**City of Portland, Maine - Building or Use Permit Application**  
 389 Congress Street, 04101 Tel: (207) 874-8703, Fax: (207) 874-8716

<b>Permit No:</b> 05-0903	<b>Issue Date:</b>	<b>CBL:</b> 066A F012001
------------------------------	--------------------	-----------------------------

<b>Past Use:</b> Multi- Family being legalized under #06-0166	<b>Proposed Use:</b> Multi-Family - upgrade & adding fire escape	<b>Permit Fee:</b> \$66.00	<b>Cost of Work:</b> \$4,500.00	<b>CEO District:</b> 3
<b>Proposed Project Description:</b> upgrade fire escape		<b>FIRE DEPT:</b> <input type="checkbox"/> Approved <input type="checkbox"/> Denied	<b>INSPECTION:</b> Use Group: Type	
		Signature:	Signature:	
<b>PEDESTRIAN ACTIVITIES DISTRICT (P.A.D.)</b>				
Action <input type="checkbox"/> Approved <input type="checkbox"/> Approved w/Condition <input type="checkbox"/> Denied				
Signature: Date:

**Dept:** Zoning      **Status:** Approved with Conditions      **Reviewer:** Marge Schmuckal      **Approval Date:** 03/09/2006

PROJECT: EXTERIOR STAIR	DRAWING: SKETCH #2 ARCHETYPE, P.A. PORTLAND, MAINE
SCALE: No Scale DATE: April 26, 05	SKa - 2

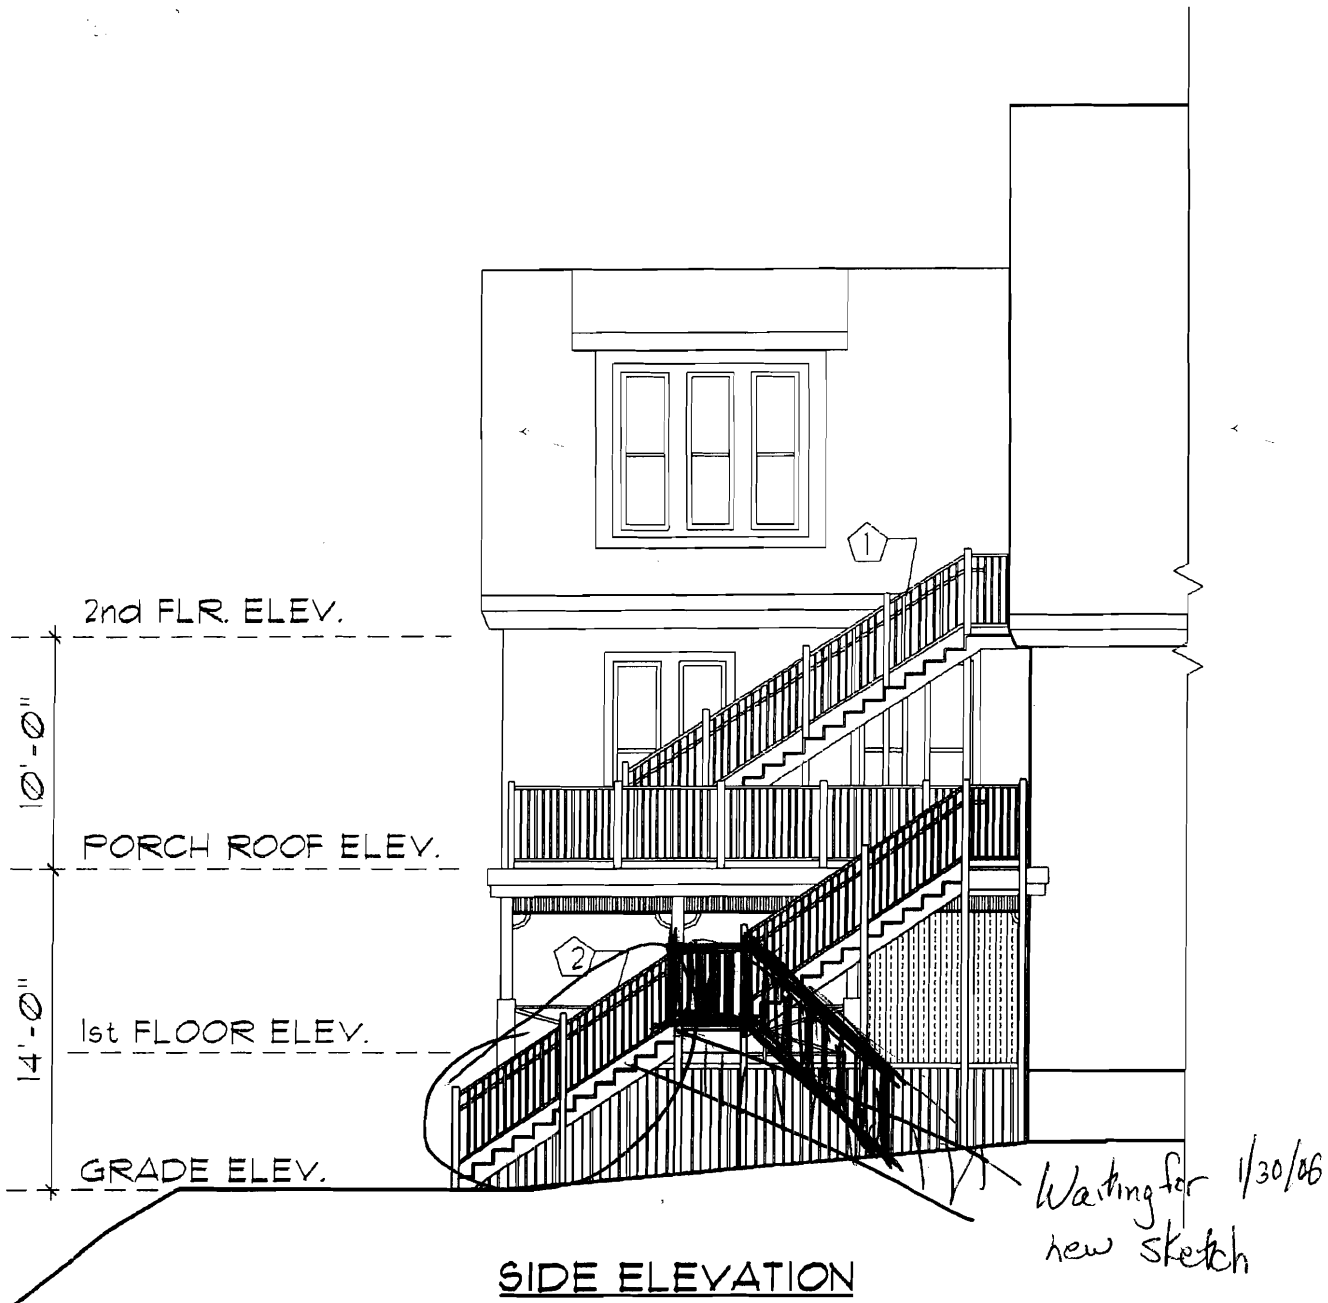
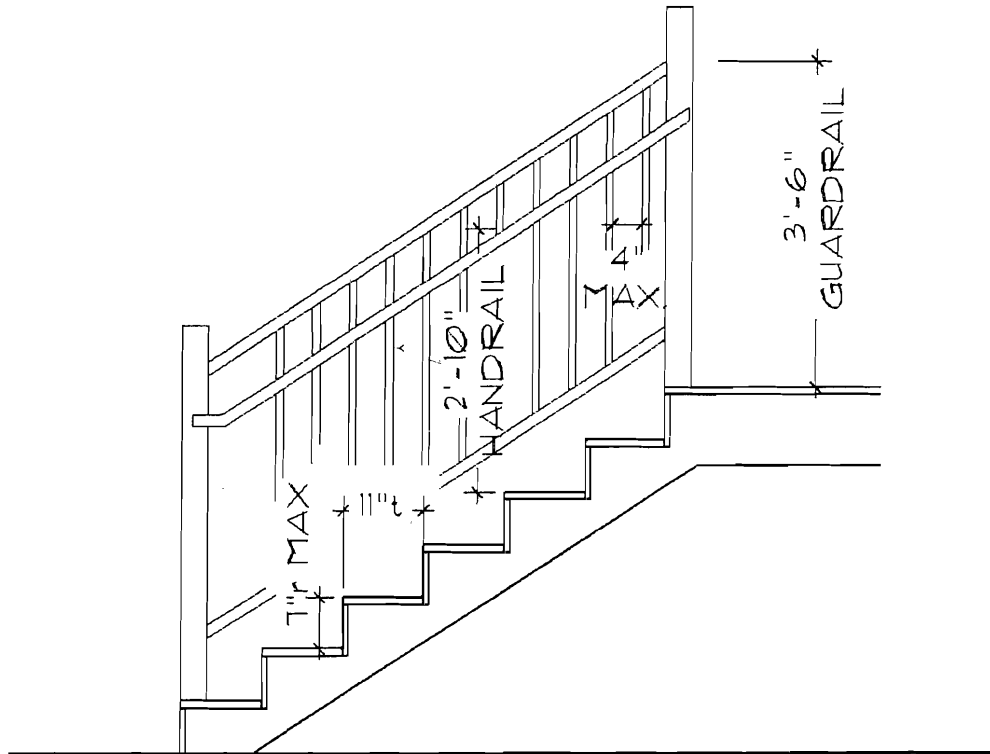
- 1) 1)All landings must be of 2" x 8" lumber instead of 2" x 6" as shown, including headers.
- 2)All Guards must be 42" with openings less than 4 inches  
All trads must be at least 11" w/ no nosing and Risers not more than 4"
- 3) SOLID RISERS!!!!!!(not open)
- 4) McNichol treads and sheathing must be installed in accordance with the manufacturer's Specs.
- 5) All windows, and doors and frames along the fire escapes must have a 45 minute rating

3/17/2006-mjn: Left Voicemail with Marc Fishman, many code deficiencies in the plan including insufficient tread depth, need structural info for existing porch roof to determine if it will hold new live and dead loads, Plans do not demonstrat window fire rating where the stairs pass.
